**KIRKLEES METROPOLITAN COUNCIL  
INVESTMENT & REGENERATION SERVICE**

**DELEGATED DECISION TO DETERMINE PLANNING APPLICATIONS**

Reference No:	<b>2025/62/90021/W</b>
Site Address:	26, John William Street, Huddersfield, HD1 1BQ
Description:	Change of use from retail shop (Class E) to hot food take-away (sui generis) installation of replacement shop front and extraction canopy to rear (Listed Building within a Conservation Area)
Recommending Officer:	Edward Cheseldine

## **Officer Report**

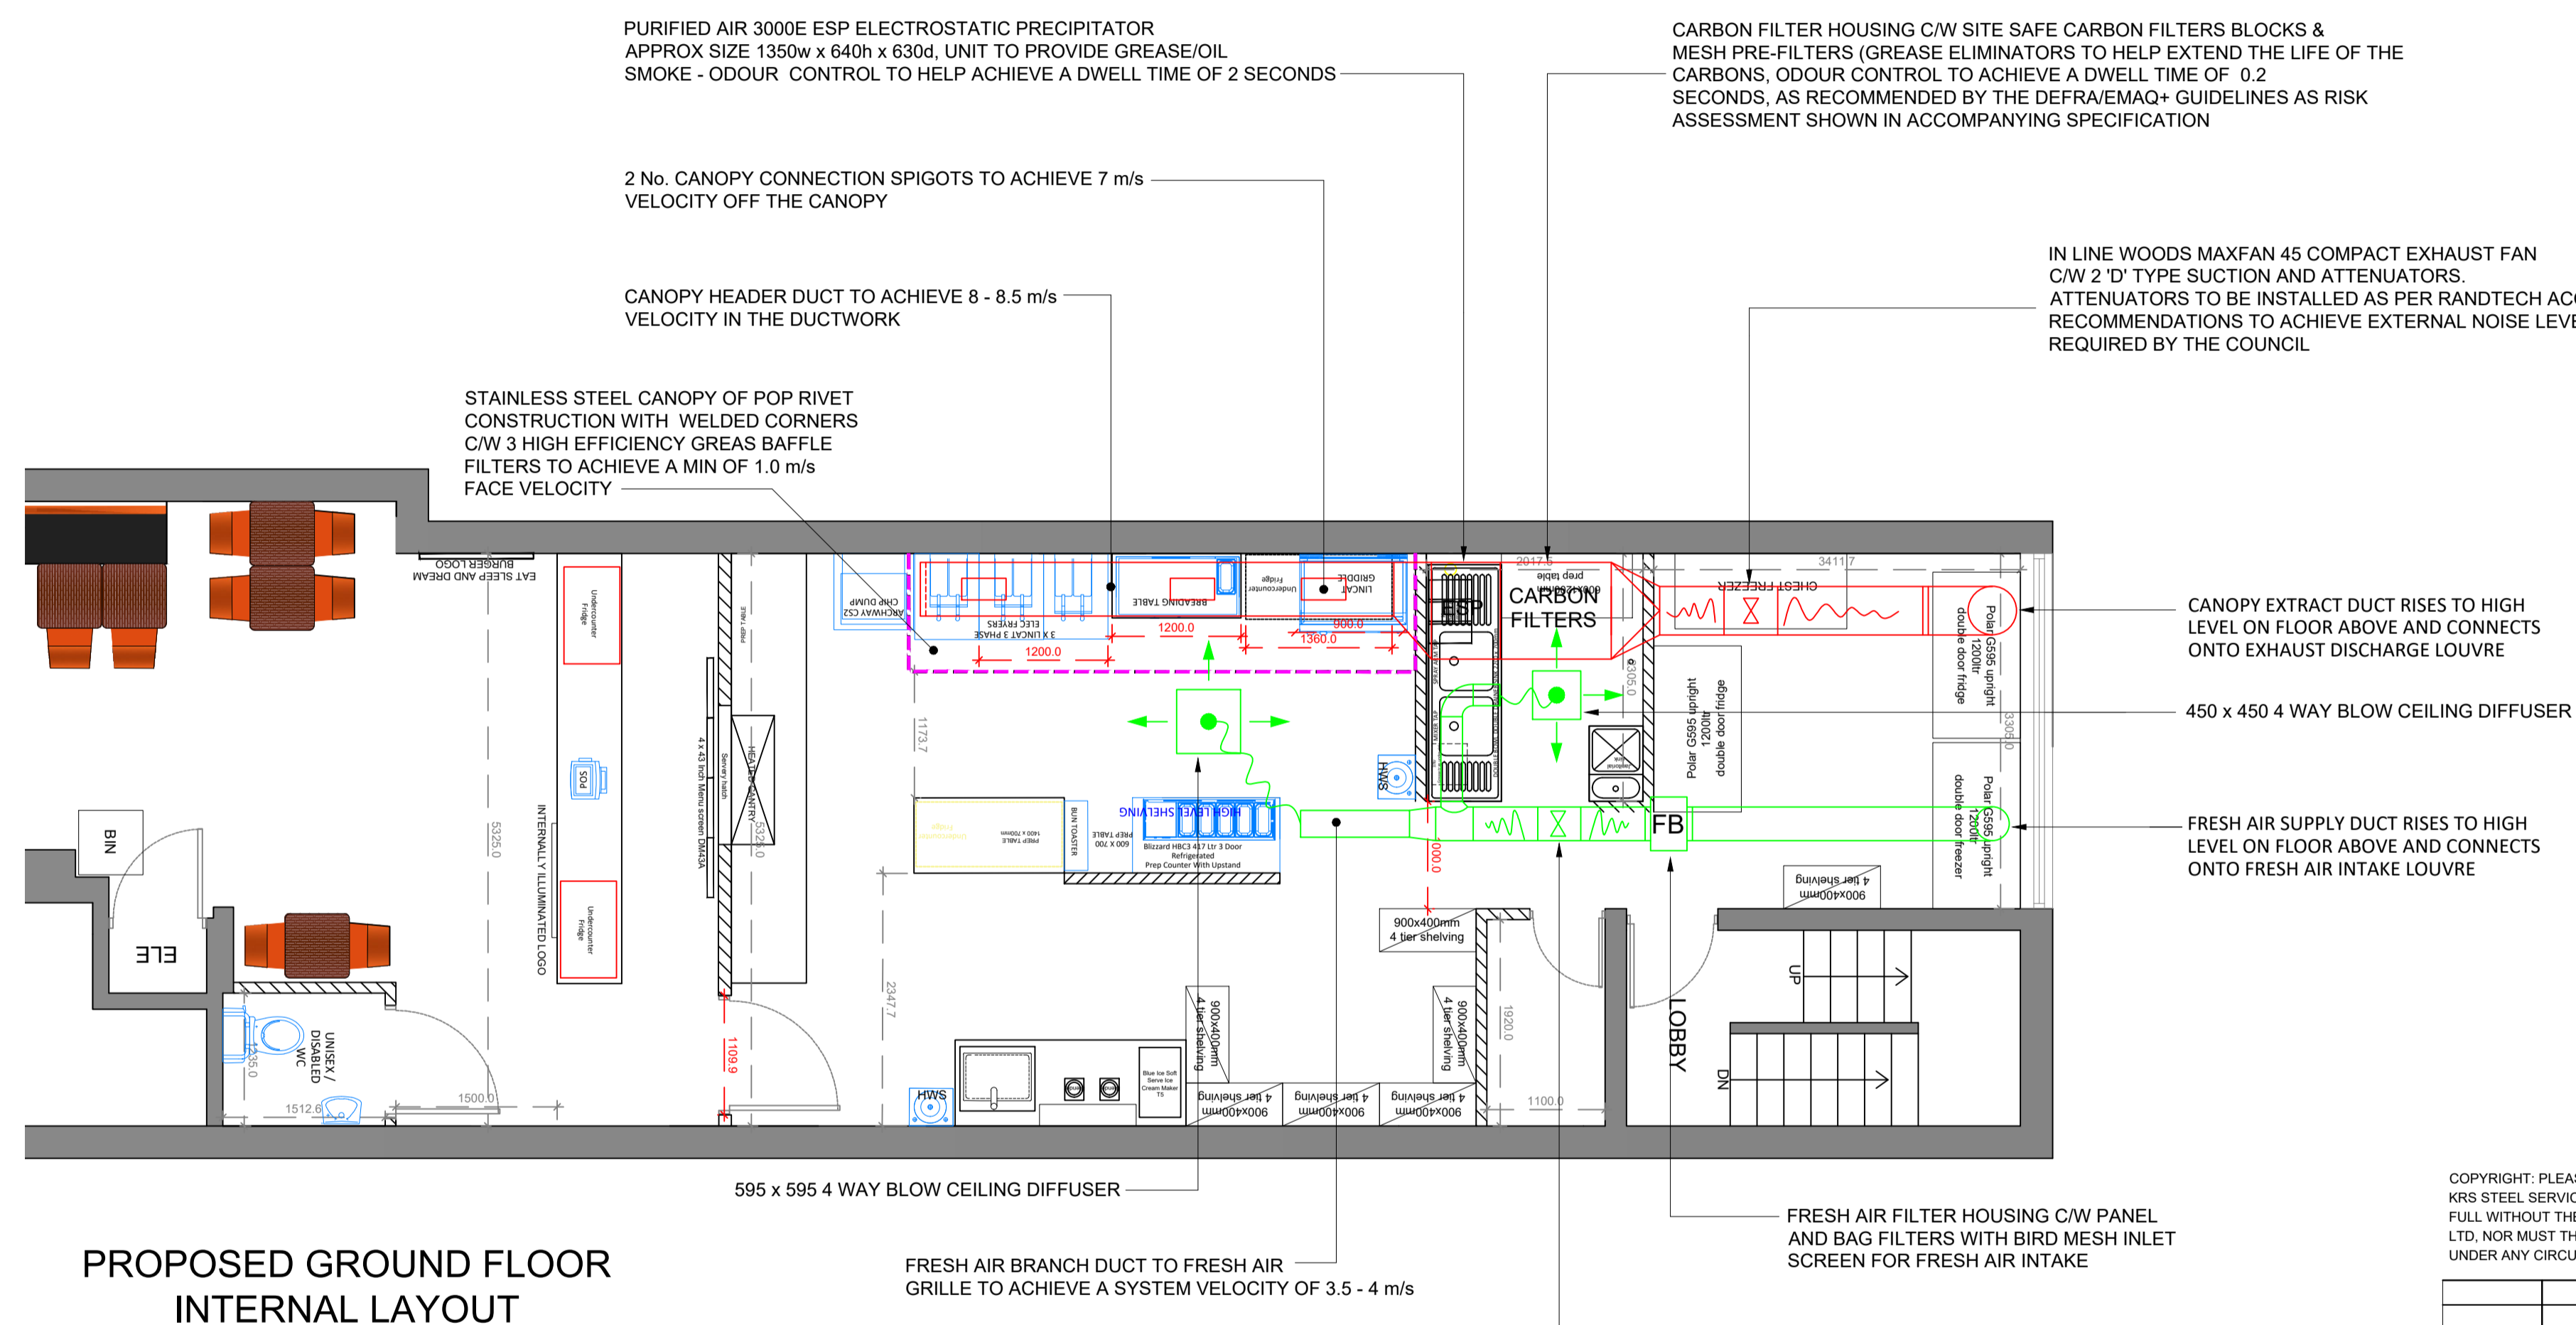
Extraction may result in odours from the cooking of food being produced which may impact upon living qualities. The applicant has submitted a Design and Specification for Kitchen Ventilation System authored by KRS Steel Services Ltd. dated 17 February 2025. The submitted drawing no.

C8425/MO1 from KRS Steel Services Ltd. shows the discharge to be at low/street level and not above eaves as stated which therefore warrants a higher score of either 15 (poor) or 20 (very poor). The resultant figure places the impact risk as very high with an appropriate level of odour control required. KC Environmental Health have rejected the report and recommended a condition for the submission of an odour impact assessment to protect the amenity of neighbouring properties. Such an impact raises concern; therefore, the condition is suitable.

4. Before food cooking commences, details of a kitchen extract system shall be submitted to and approved in writing by the Local Planning Authority. The details shall provide the following information:

- Based on the risk assessment, details of the proposed methods of odour control and dispersion of any extracted odours. The effective stack height (discharge height plus plume rise) must be high enough to ensure that adequate dilution takes place before the plume interacts with the nearest sensitive receptor.

Existing Front Elevation

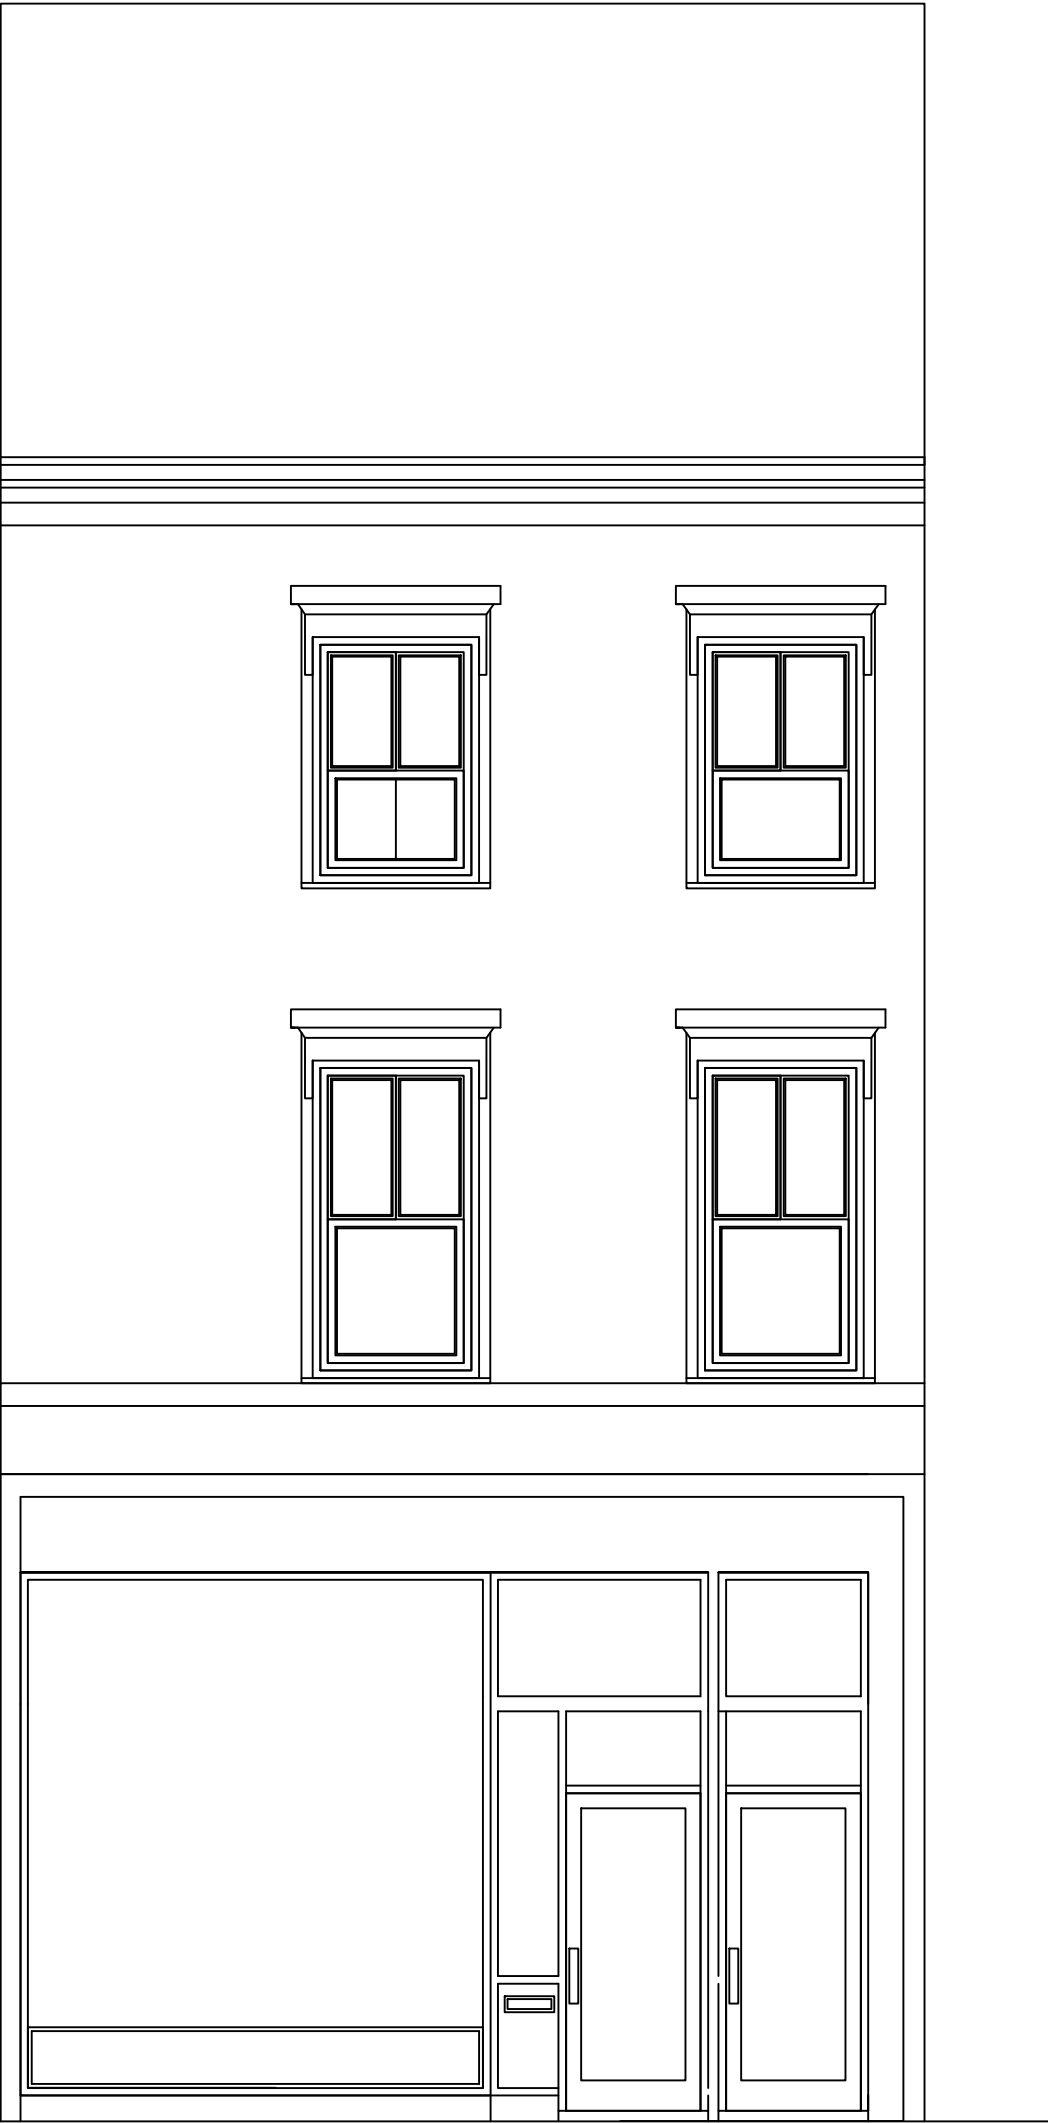
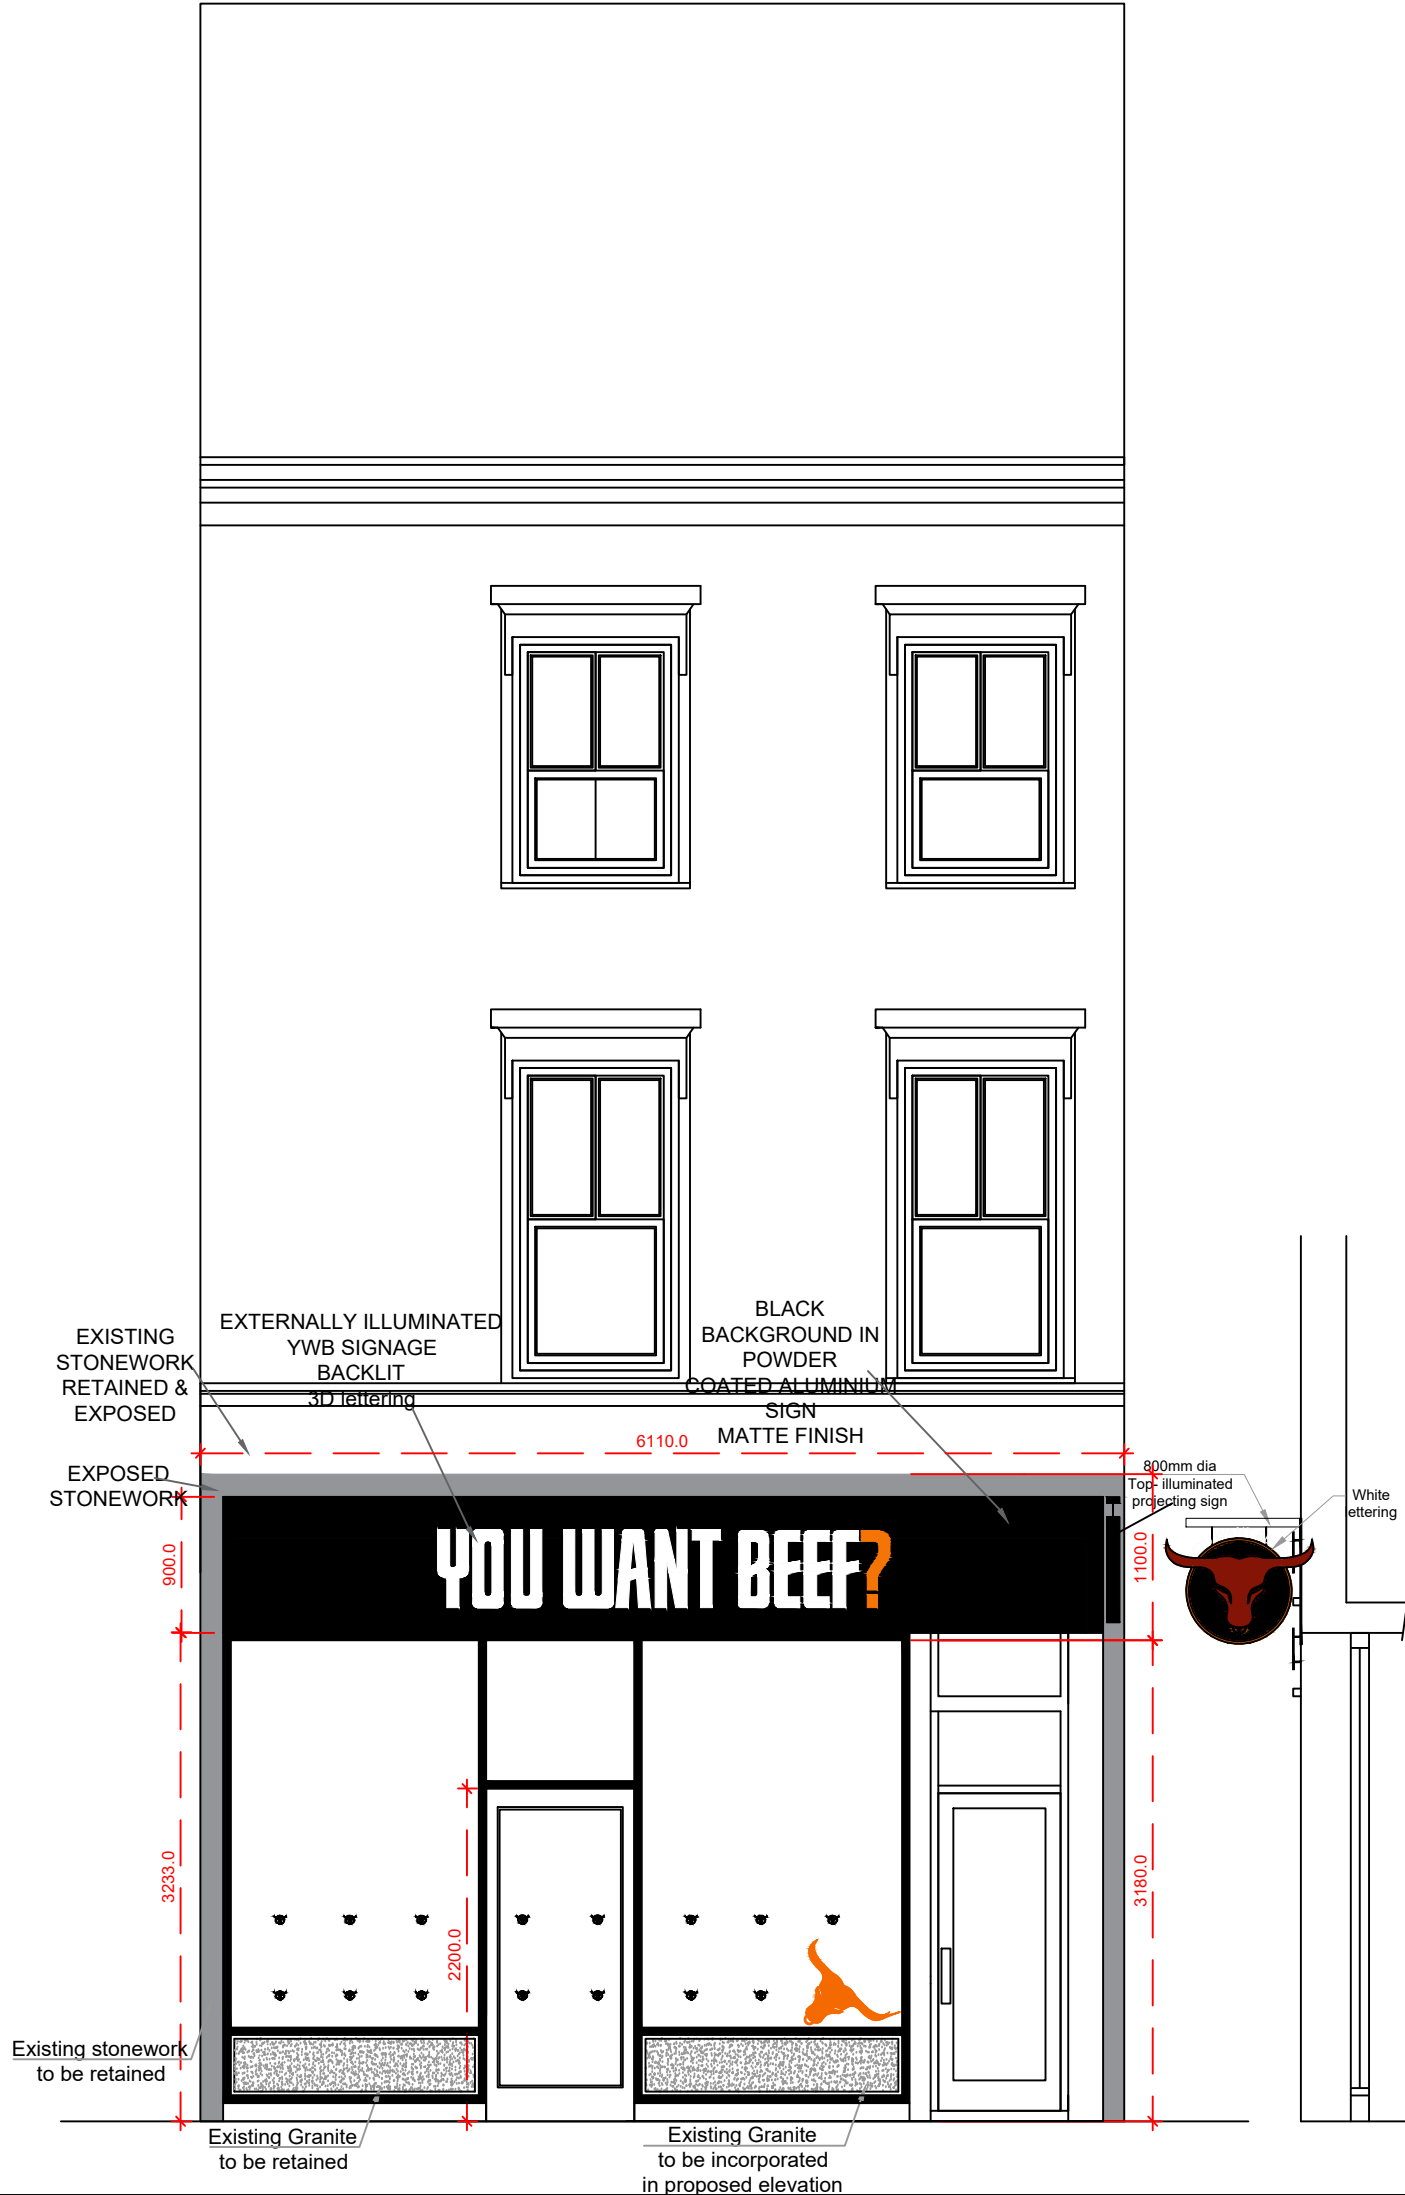
*On behalf of Huddersfield Civic Society (HCS). The design of the shopfront replicates the low quality design of others along John William Street, a matter about which HCS has campaigned for many years and we had hoped the Conservation Area Appraisal, Management Plan and Shopfront Guidance consultancy work more recently carried out by Purcells was establishing a better standard for shop fronts along this critical and architecturally important street. Moreover, the Heritage statement needs to be amended as the initial submission makes reference to the wrong address.*

- *Objection to the granite riser - The riser is in a rich red and black 'granite' called Imperial Mahogany. It comes from Milbank, South Dakota USA. Originally formed in a magma chamber deep in the earth,*

Officers had concerns in relation to the initial plans to the front façade and there was outstanding information in terms of materials.

The proposed refurbishment of the front façade includes the installation of a fascia board within the existing shop front surrounds. The overall design is considered to be acceptable. Lettering is appropriately spaced being set in from the sides and leaving space above and below the lettering. It will be raised by 100mm. The aluminium signs will have a matte finish which is appropriate on a listed building. Features of the 1960's shopfront are being retained, including a granite riser and the surrounds. A metal hanging sign will be installed with a motif of a bull's head with white elevated text. It will appear modern but within the context of the shop front design.

*Officer Response:* There has been a concerted effort by the Officer to illustrate what would be acceptable in terms of an appropriate design for the shopfront. Amended plans have been received, which are considered to address all design issues, retaining and repairing features of the listed building and 1960's shopfront.

*Officer Response:* There has been a concerted effort by the Officer to illustrate what would be acceptable in terms of an appropriate design for the shopfront. The granite riser is set to be retained with part of it being repurposed.
